Rezoning Transportation Analysis
Petition Number: Insert Zoning Petition #2021-221
General Location Identifier: 04121119

Revision Log:

Date	Description
02-24-22	First Review (TM)
04-20-23	Second Review (ME)

RZ-2.0

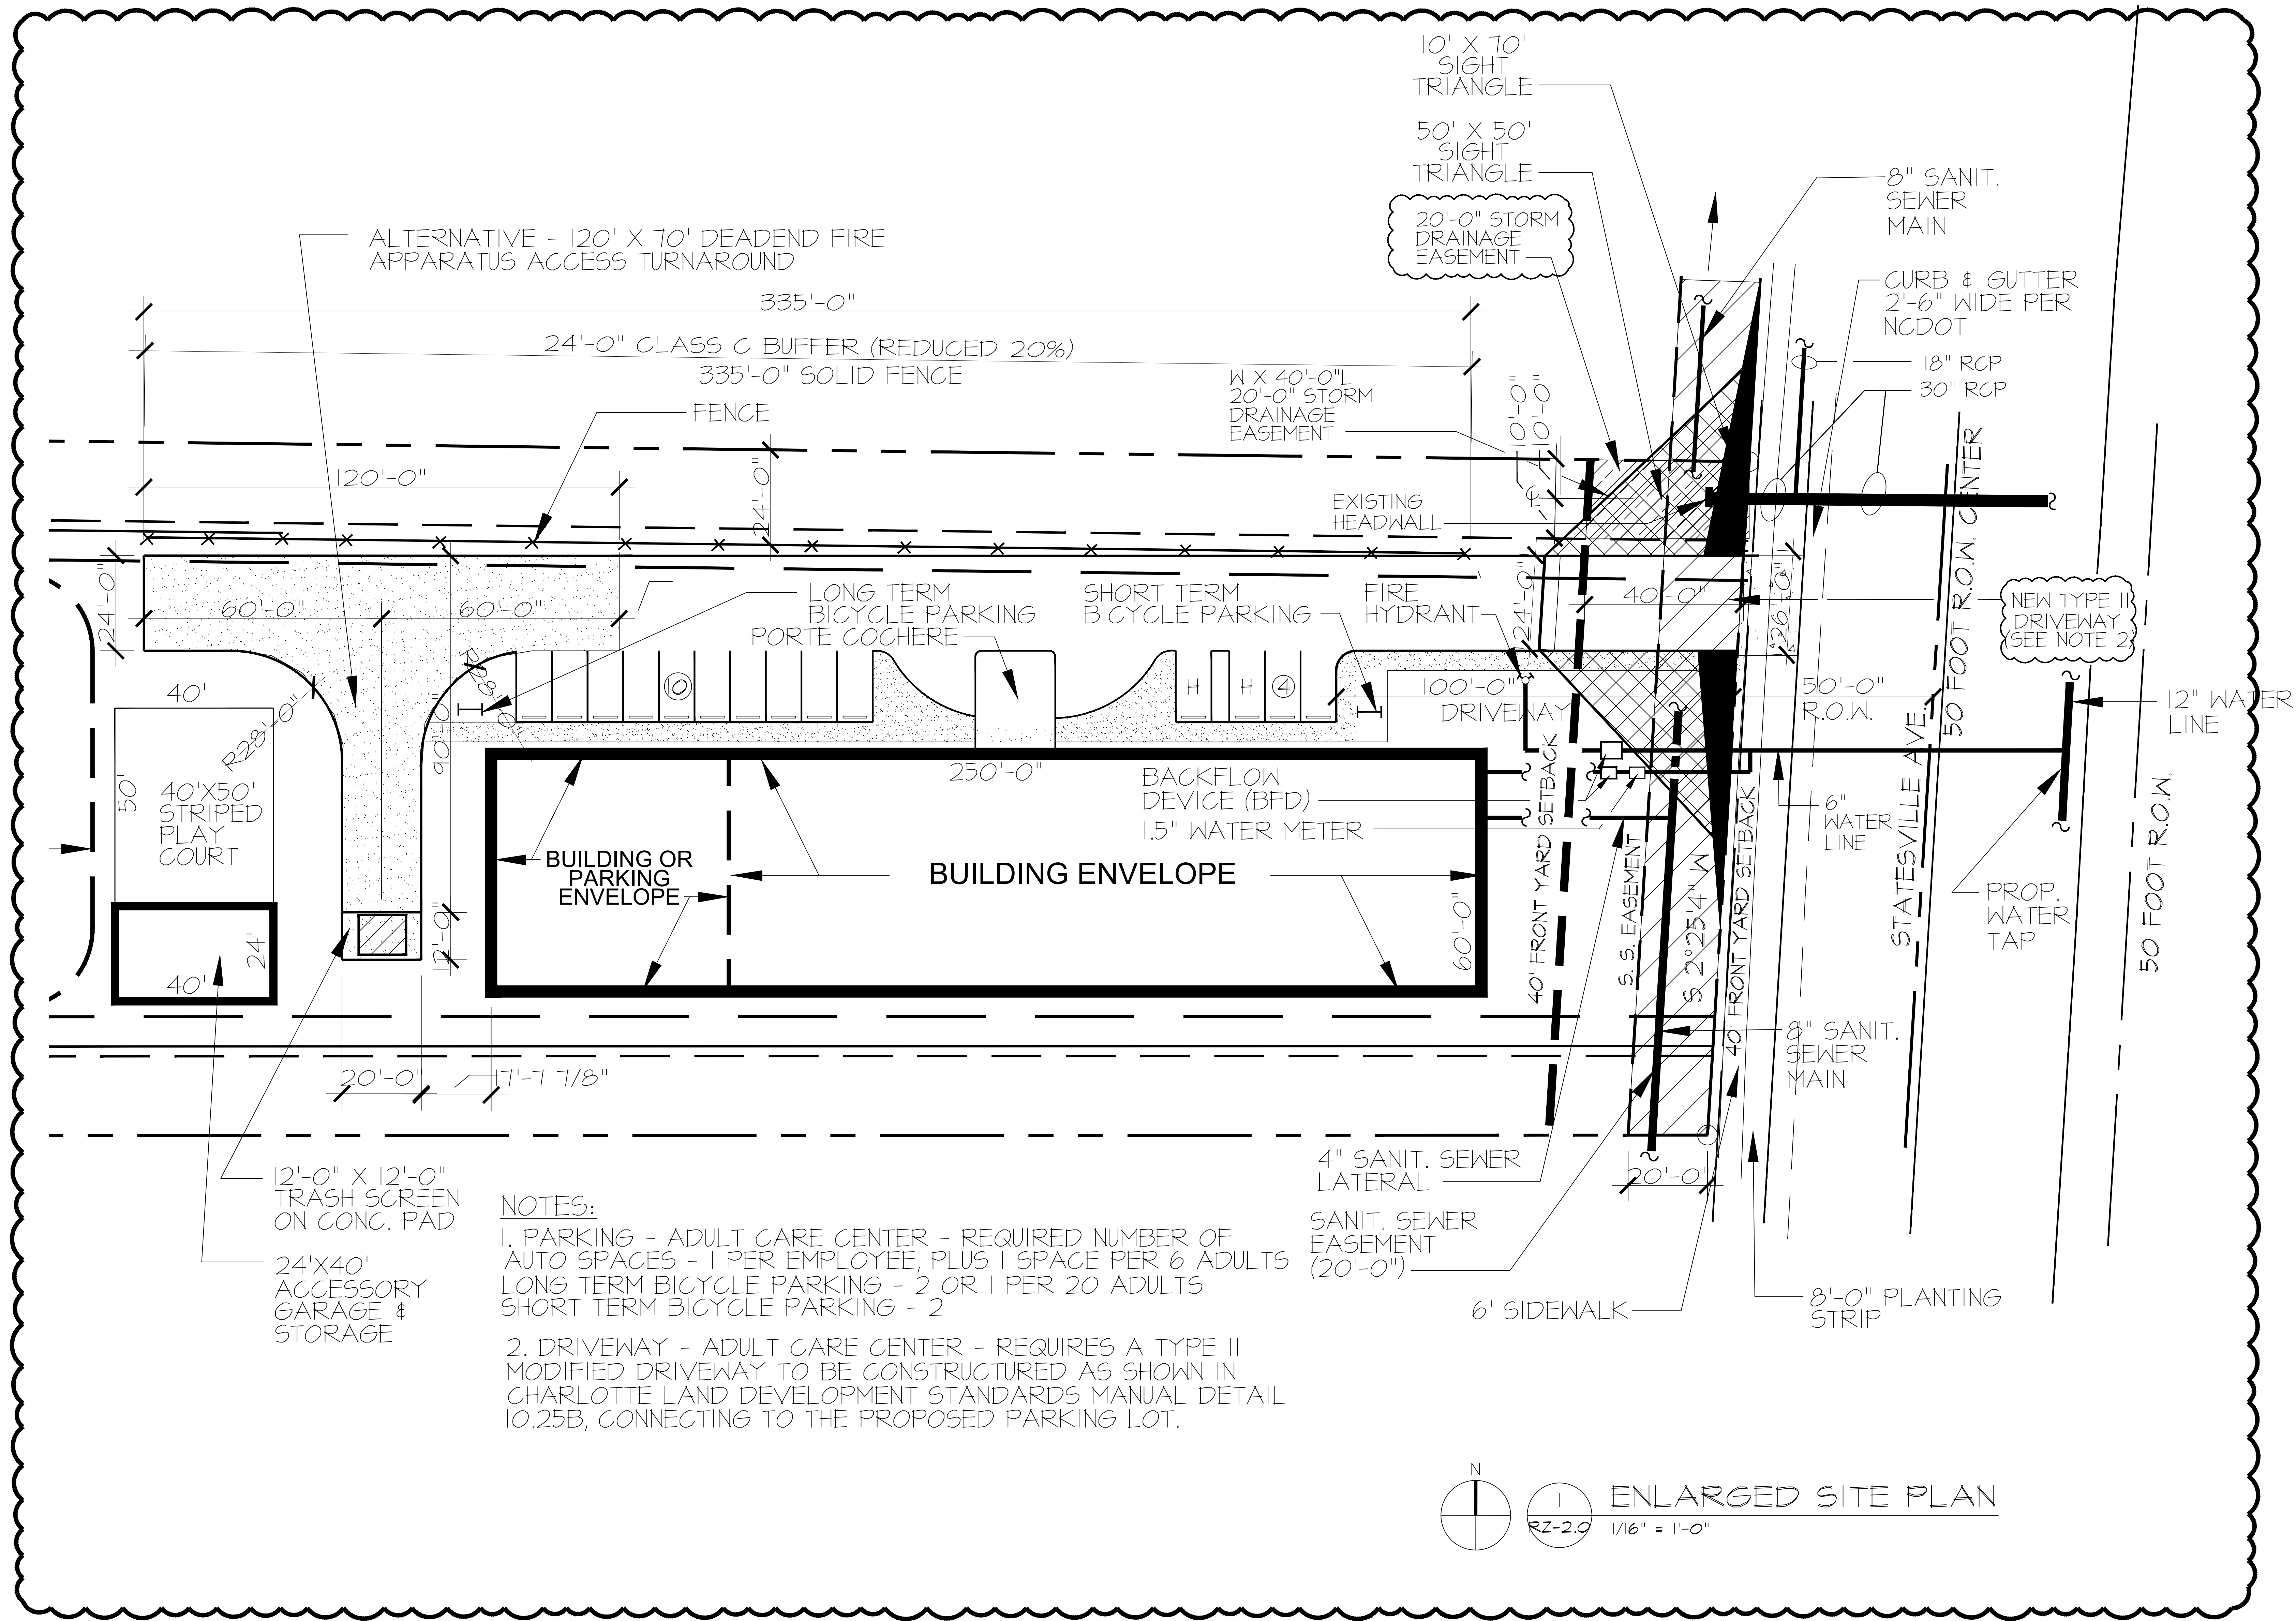
- 5. **Outstanding Comment From 02-24-22:** Revise site plan and conditional note(s) to commit to construct a Type II Modified driveway as depicted in Charlotte Land Development Standards Manual detail 10.25E connecting to the proposed parking lot.

Clarifying Comment 04-20-23: There is a label on the site plan referring to the Charlotte Land Development Standards Manual detail 10.25B and it should reference detail 10.25E as stated in conditional notes.
